Crime Impact Statement

Proposal: Change of Use from an antique shop to a wine bar, Unit 4 The Business Centre, 5 Stanley Street, Longridge

Planning Reference 3/2017/0027

PROPOSED GROUND FLOOR PLAN

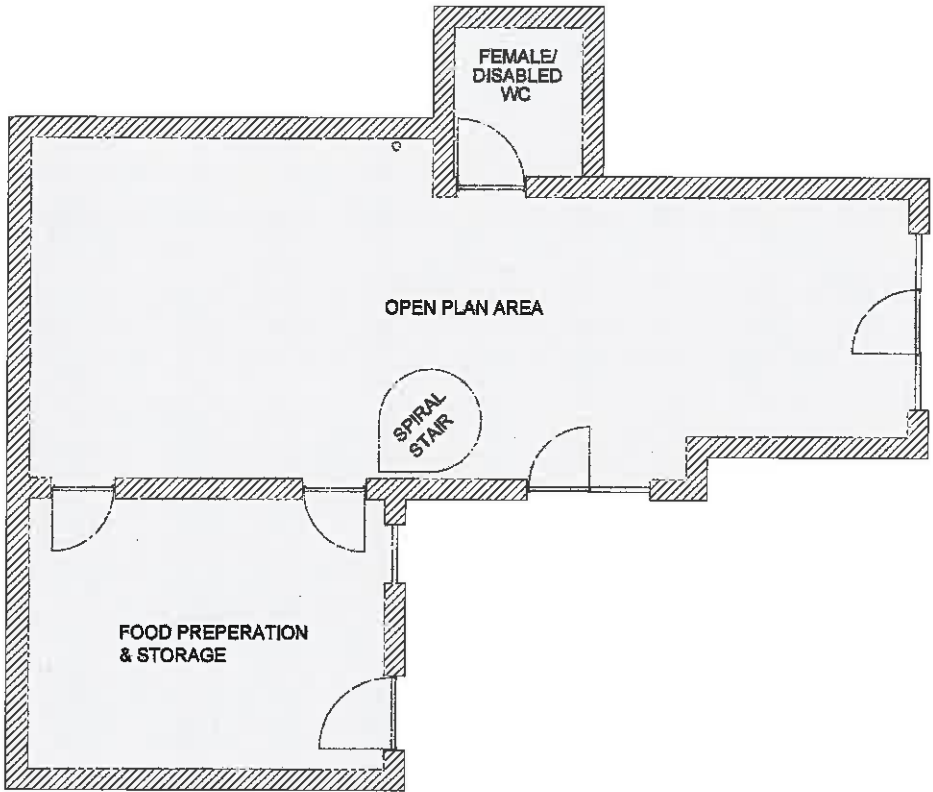
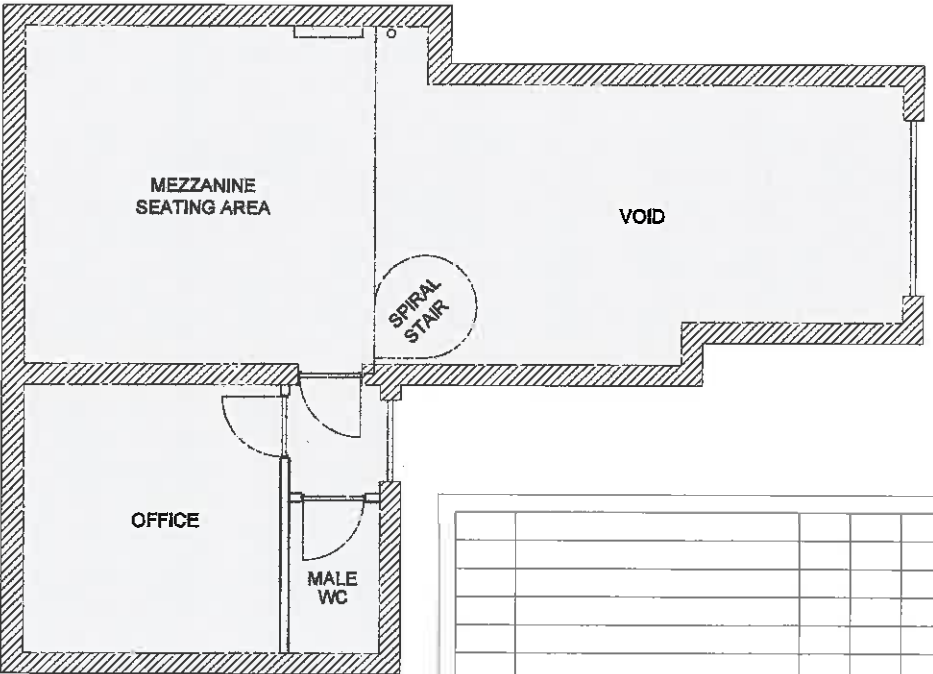
- Replacement doors and windows must be PAS 24/2012 certificated. This building is tucked away down a side street with limited natural surveillance from passing pedestrians or vehicles to monitor suspicious behaviour. **Reason:** to deter forced entry and burglary.

- Replacement glazing should be laminated and opening windows should be fitted with restrictors. **Reason:** to deter attempts at burglary, criminal damage and opportunist theft.

- Internal doorsets leading to private areas such as the office must be fitted with an access control system such as a keypad. The safe should be securely fixed to the floor or wall. **Reason:** to slow down the movements of an intruder should they gain unauthorised entry into the building.

- Due to the lack of natural surveillance around the building an infrared CCTV camera system should be fitted that provides full coverage internally and externally. A camera should be fitted to provide a clear head and shoulders shot of all persons entering the premise via the main front door. The server/bar area and seating areas on both the ground and first floor should be covered. Recording equipment must be stored in a locked room (the office) which is fitted with a PIR motion sensor linked to the intruder attack alarm. **Reason:** to deter and detect burglary, theft and assault.

- An intruder attack alarm should be installed that is monitored via an Alarm Receiving Centre. 2 confirmed activations are required for a Police response. Impact sensors should be fitted to all doors and windows and PIR motion sensors fixed internally. **Reason:** to deter crimes including burglary.

- Dusk till dawn lights should be installed at all external doorsets including the staff and emergency exits.
Reason to promote natural surveillance and make a less attractive target for an intruder as the chance of being seen is increased.
